Application No: AB/24/22/L
Site Address: Flat 67 High Street Arundel BN18 9AJ
Description of works: Listed building consent to convert the first floor Restaurant into 3 No bedrooms and remove one bedroom on the second floor.

OWPC45951

EXISTING FIRST FLOOR PLAN

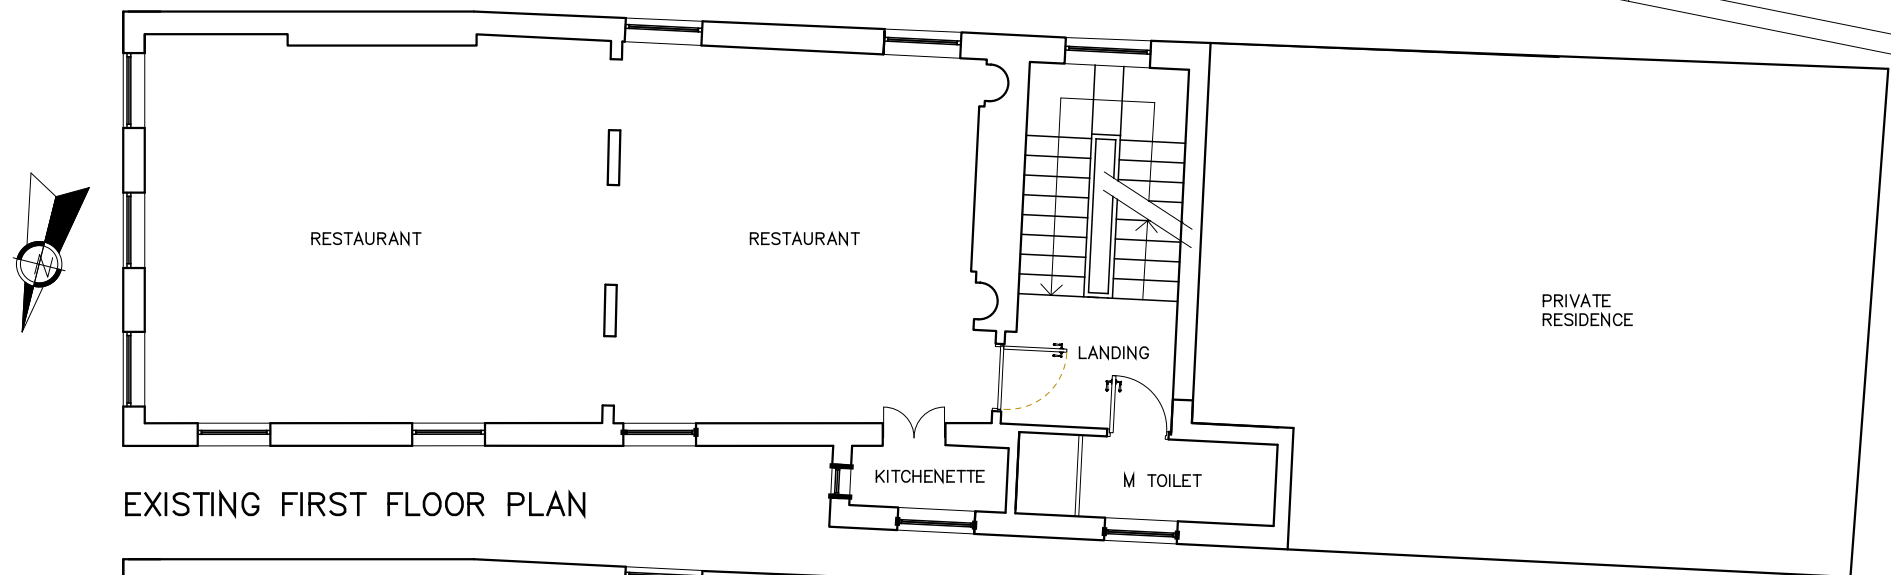
The Committee objected to the Application. In terms of the amenities we would like to ask whether this is compliant with building regulations on the grounds that there does not appear to be any bathroom / washing facilities for habitation purposes.
